The Secretary
NSW Department of Planning and Environment

29 September 2022

I refer to the Department's email of 27 September 2022 regarding the Environmental Impact Statement (EIS) for State Significant Development SSD-19425495 Smithfield Recycling Centre for use of an existing warehouse (operating 24 hours 7 days a week) to receive up to 150,000 tonnes per annum of domestic and commercial recyclable materials and sort these materials into categories for transportation to dedicated reprocessing facilities at 132-144 Warren Road, Smithfield (Lot 2 DP 1230452) in the Cumberland City Council Local Government Area (LGA). Submissions need to be made to the Department by no later than 26 October 2022.

Subject: Proposed State Significant Development 132-144 Warren Road, Smithfield.

Ref:	Scale: NTS
File name 20220808 SMF_MRF_GA_DWG200 LH	SHEET PAGE 1 OF 5
SMITHFIELD MRF	
Note: SITE OVERVIEW	Revision 12

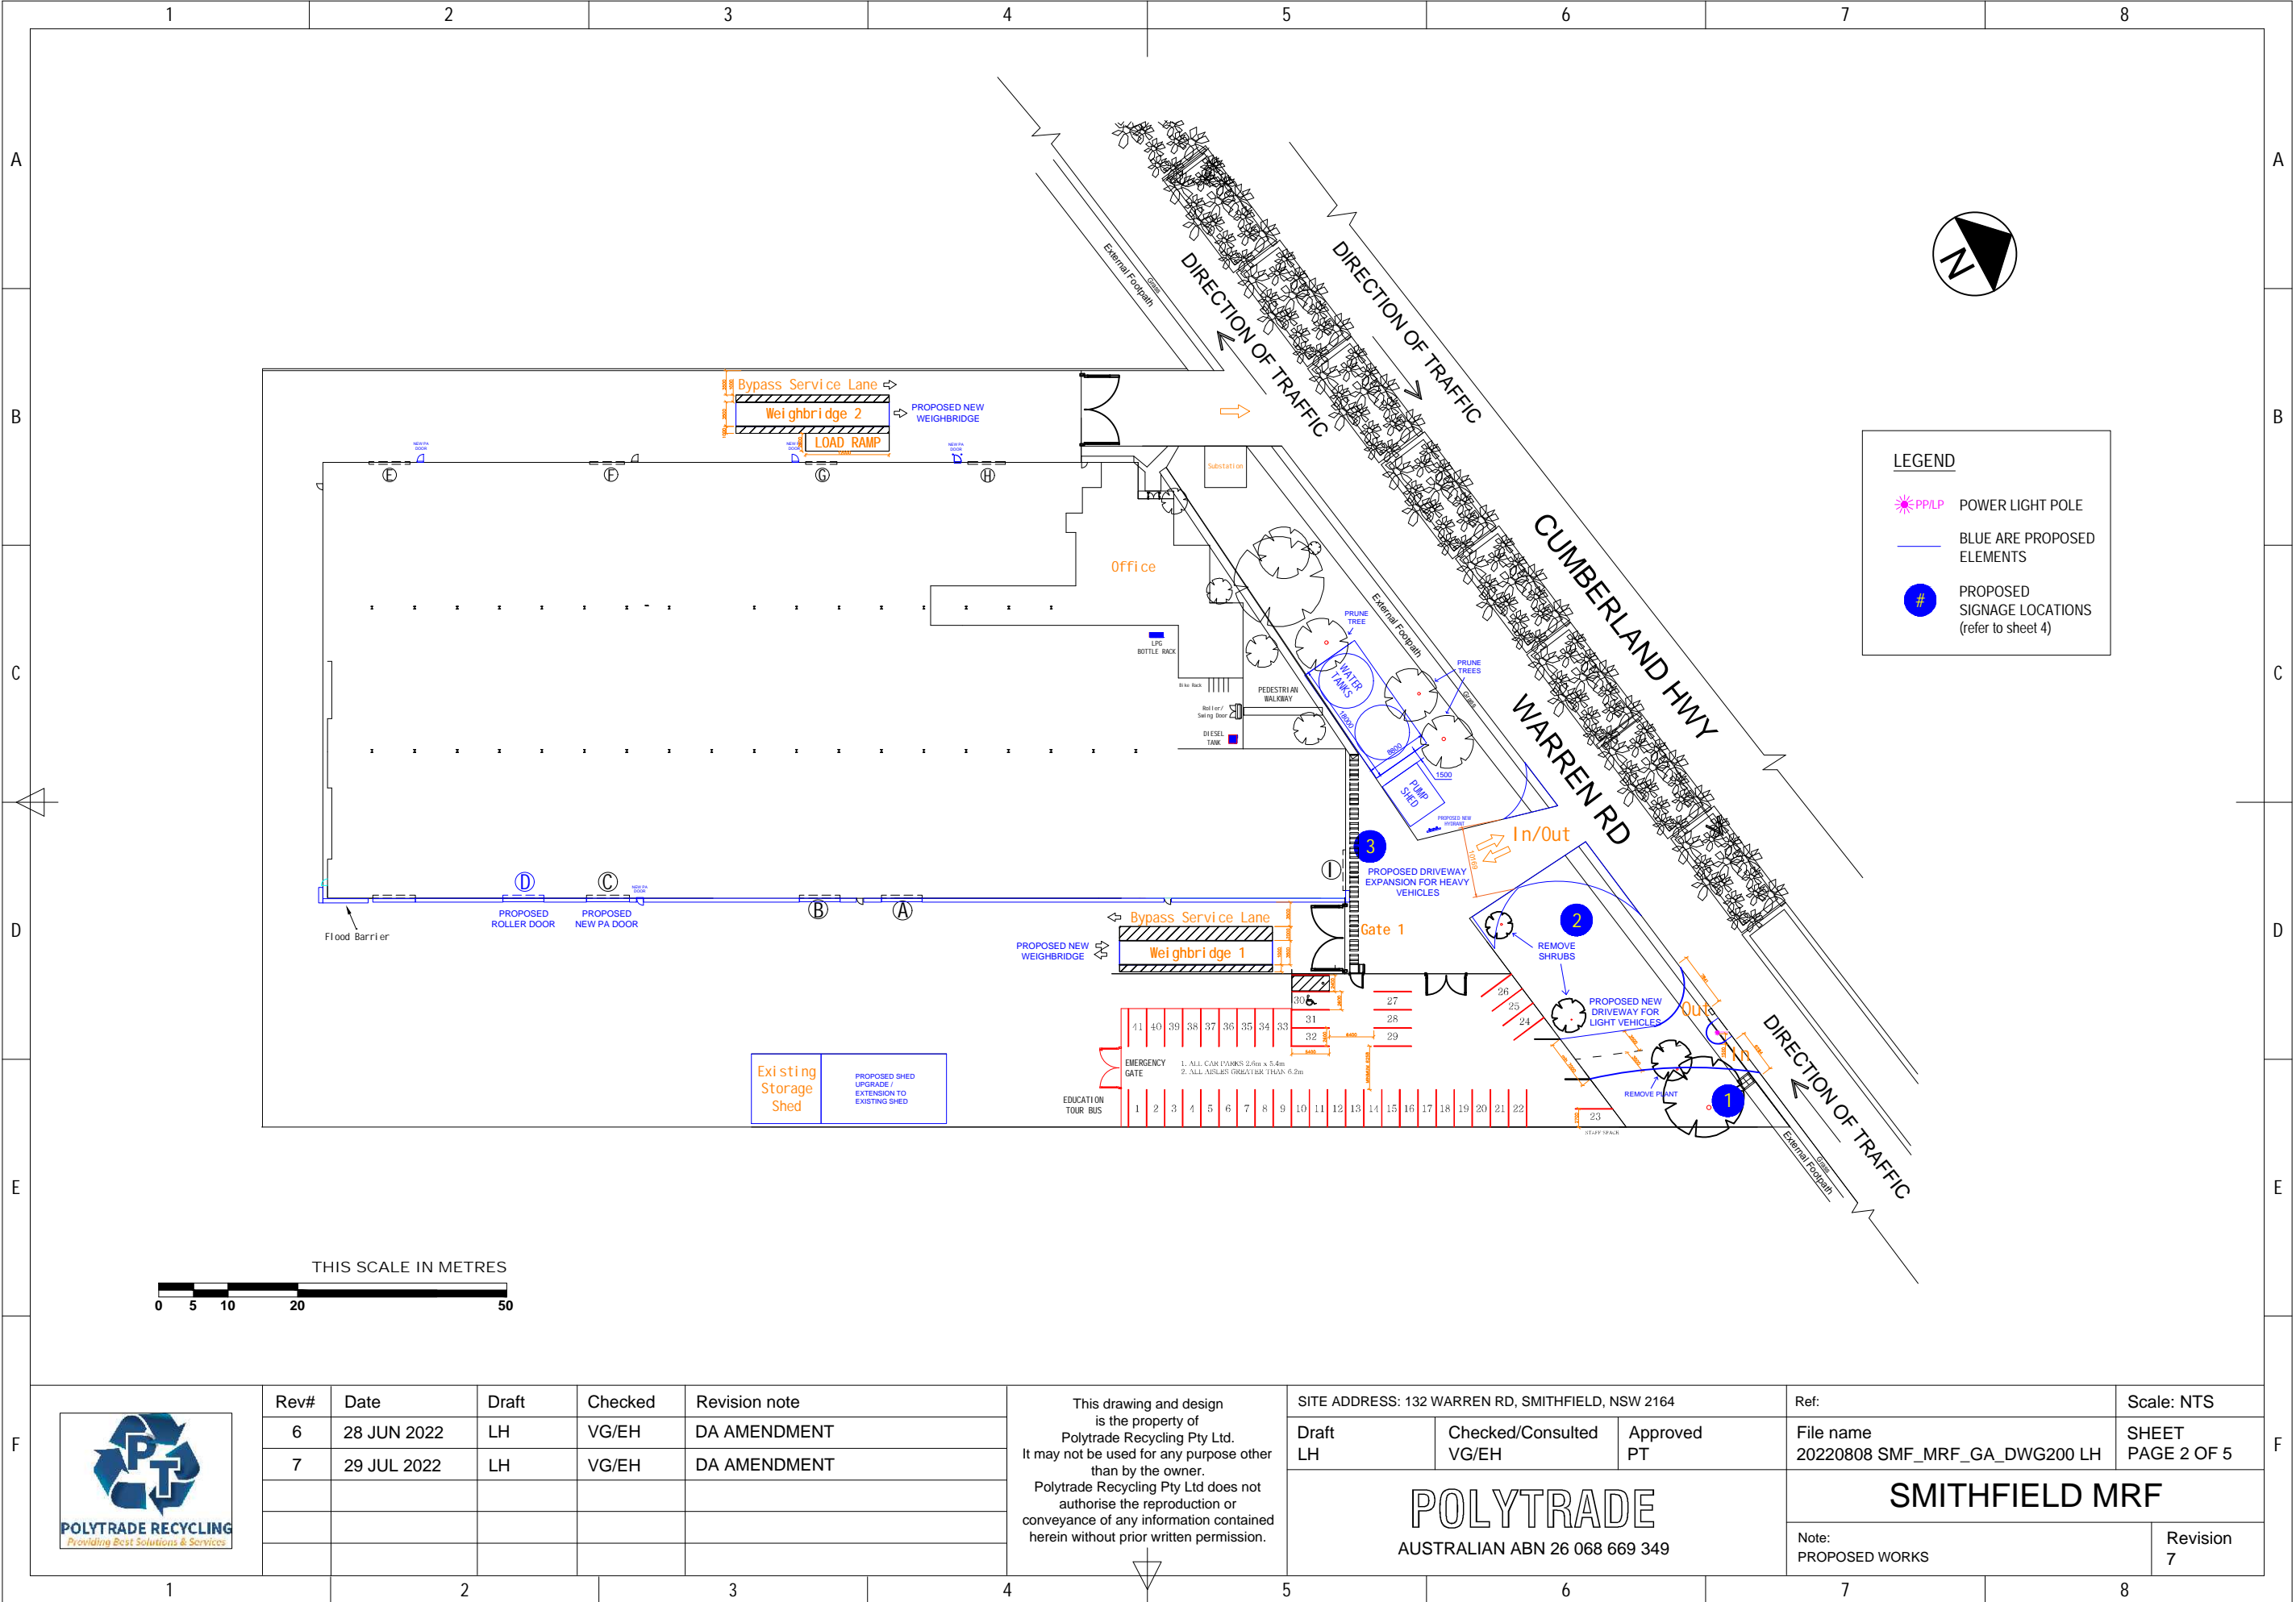
It should be noted that the owner of the site has obtained approval to move the padmount station from the present location to the vegetated area to the north. The Endeavour Energy reference number is UIL6091 for the substation works.

As shown in the below Site Plan from Endeavour Energy's G/Net Master Facility Model, padmount substation no. 4513 and some of the associated underground cables are 'Proposed Removed' (indicated by the  colouring).

Endeavour Energy has noted the SEARs Scoping Report indicates 'Some minor works to the shed and site are proposed'. It also indicates minor excavation may be required as part of this proposal for the installation of two weighbridges – one proposed on the western side of the shed within the easement (which is not mentioned in the SEARs Scoping Report) and which may be prohibited. The applicant must provide full details of any works proposed within the easement to Endeavour Energy's Easements Officer for assessment. These proposed works may be allowed as controlled activities provided they meet the minimum required safety requirements and controls. However please note that this does not constitute or imply the granting of permission by Endeavour Energy to any or all of the proposed encroachments and / or activities within the easement.
